Subject: Planning Consultation on: A/46/22/RES

Application ref: A/46/22/RES Addition to comments

Description: Approval of reserved matters following outline consent A/122/19/OUT and varied by A/207/21/PL for the construction of 7 No dwellings with associated public open space, landscaping, parking, ecological mitigation, infrastructure and earthworks. This application is a Departure from the Development Plan and is in CIL Zone 3 and is CIL liable as new dwellings.

Location: Phase 1 - Land off Arundel Road Angmering

Planting Plan - S401
1 of 4

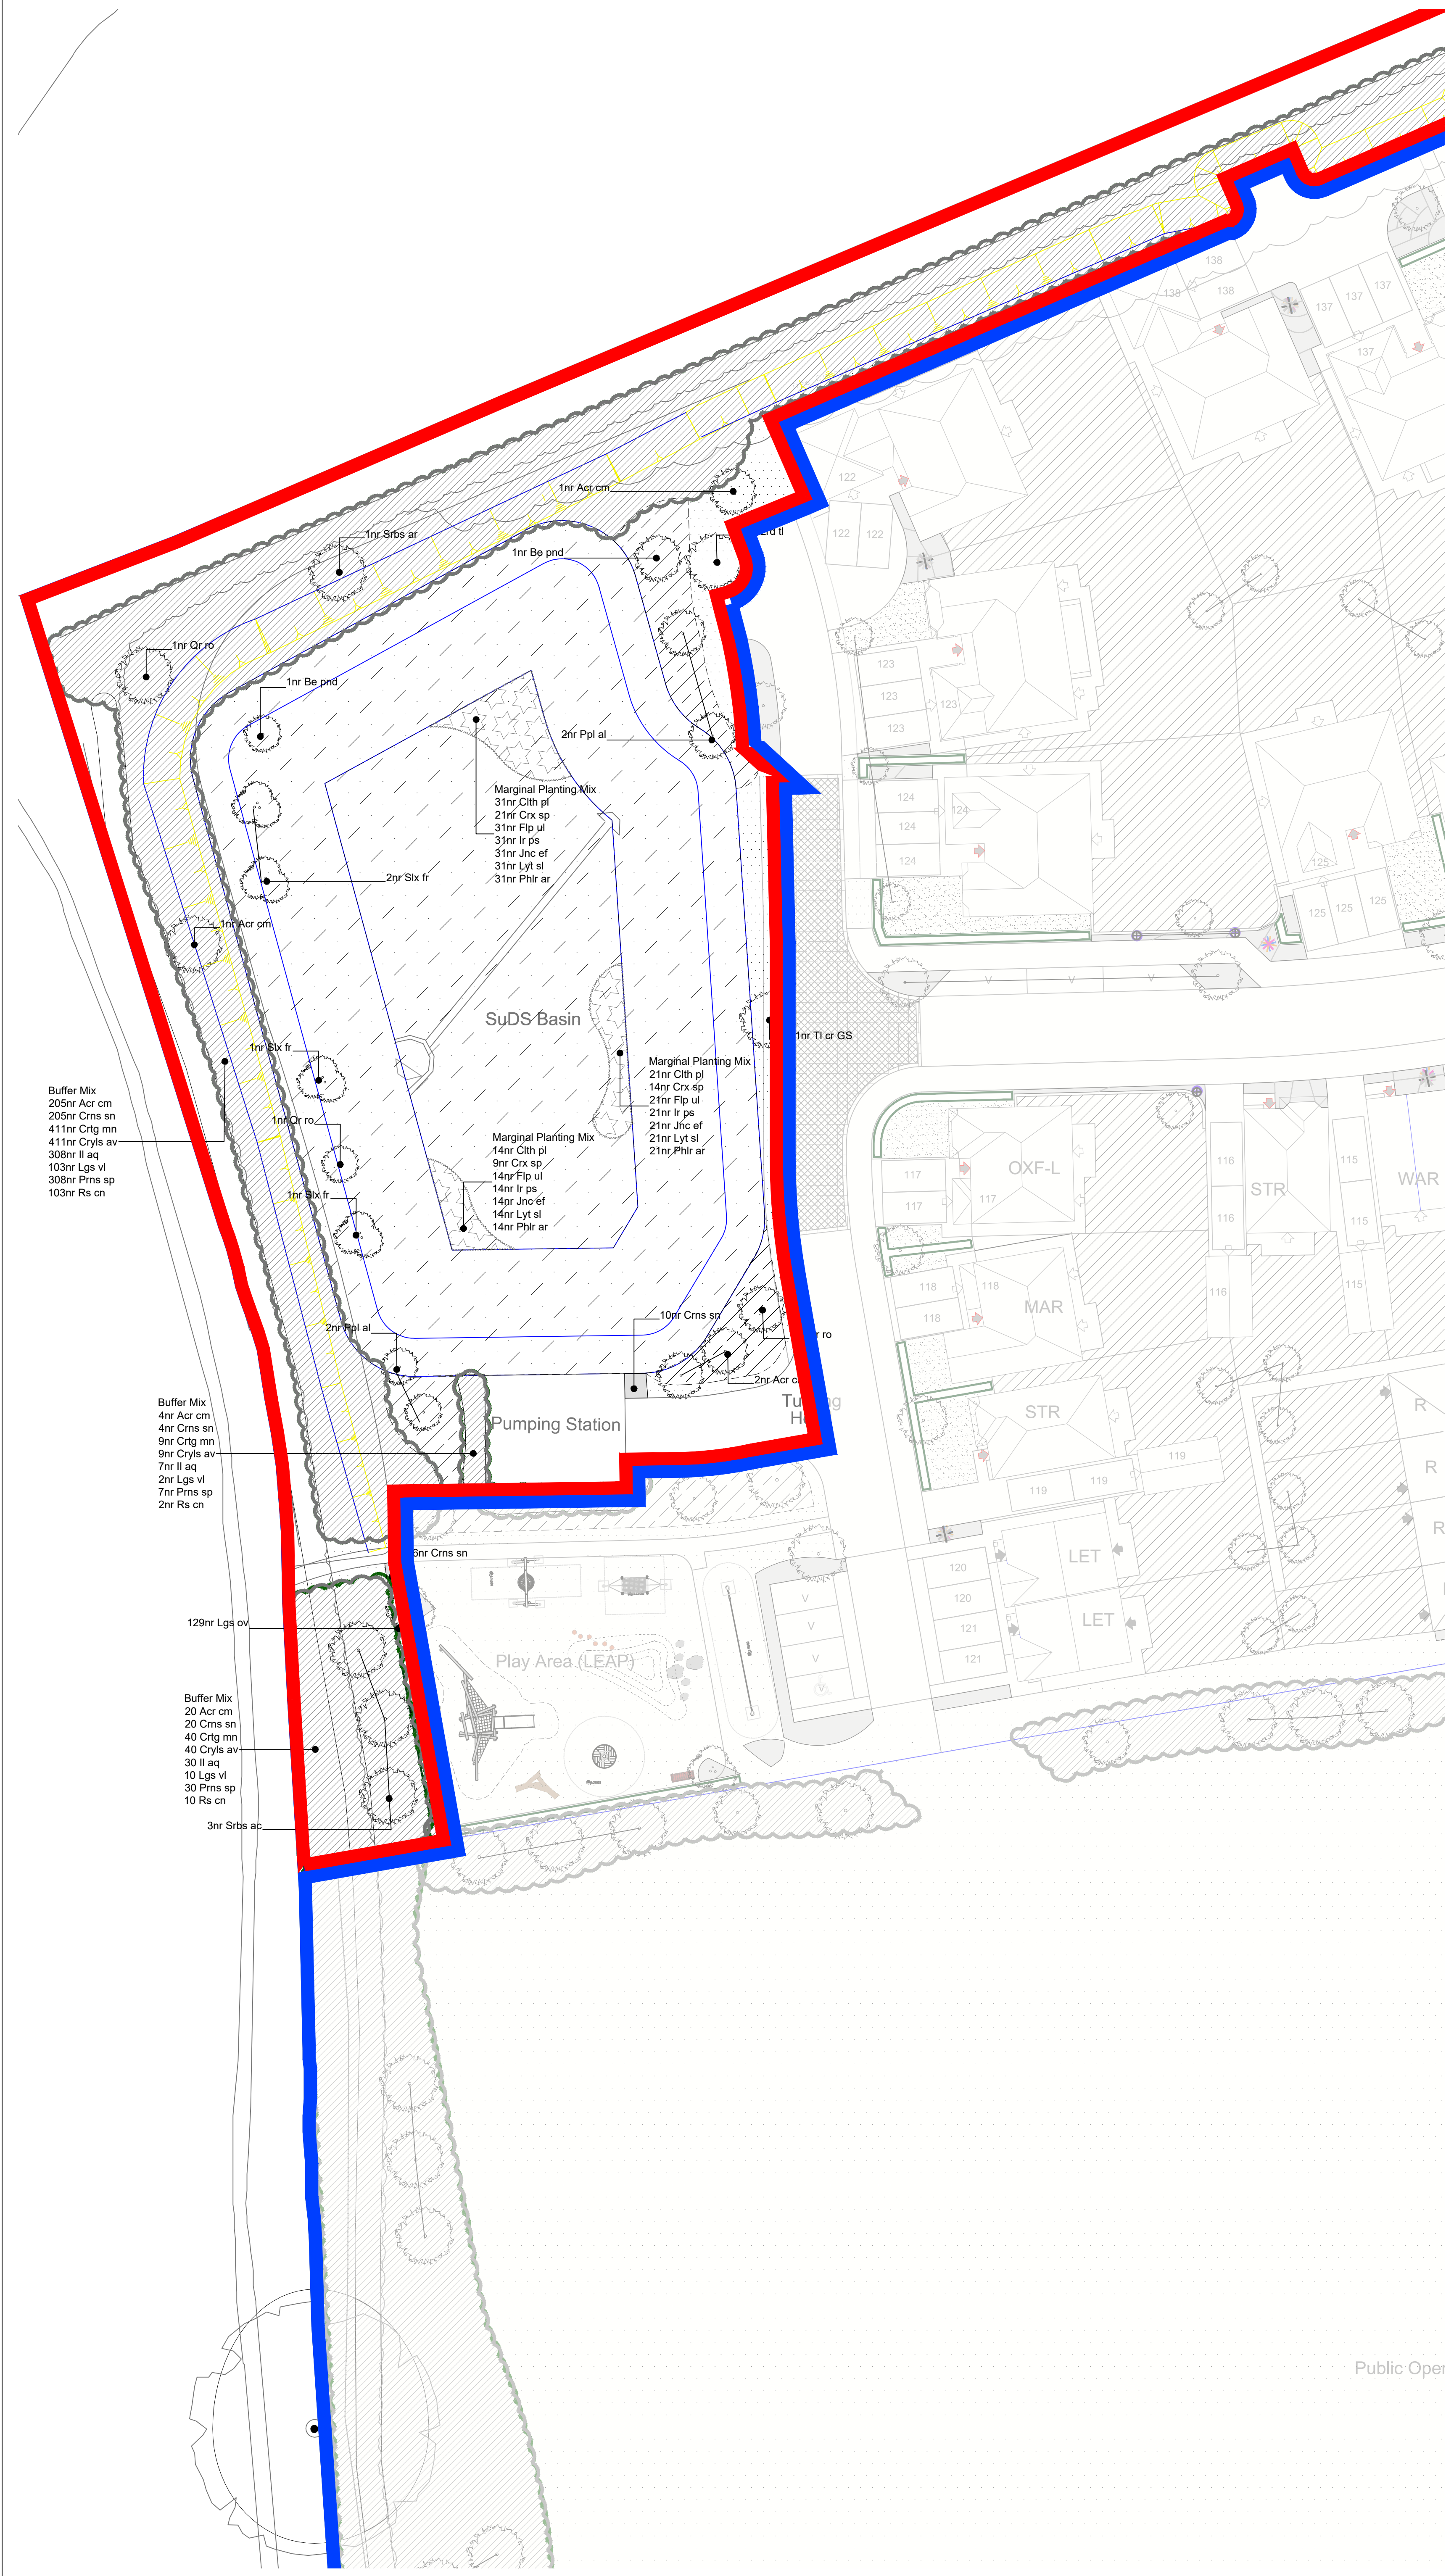
Following the submission of the revised Tree and Shrub Palette Schedule – JSL3924-550 B, Landscape strategy dwg 120 REV E, Planning and DAS document and detailed Planting Plans 1-4 of 4 Rev's C & D. the recommendation would remain the same in that the proposals would be suitable for this small section of the site however these documents show the picture for this section of the site it does not detail how this will be integrated within the wider site context.

This application has provided landscape detail in the form of a Landscape strategy dwg 120 REV A, Planning and DAS document, Tree and Shrub palette document and detailed Planting Plans 1-4 of 4 Rev's A. Whilst these documents show the picture for this section of the site it does not detail how this will be integrated within the wider site context which is information that should be a consideration.
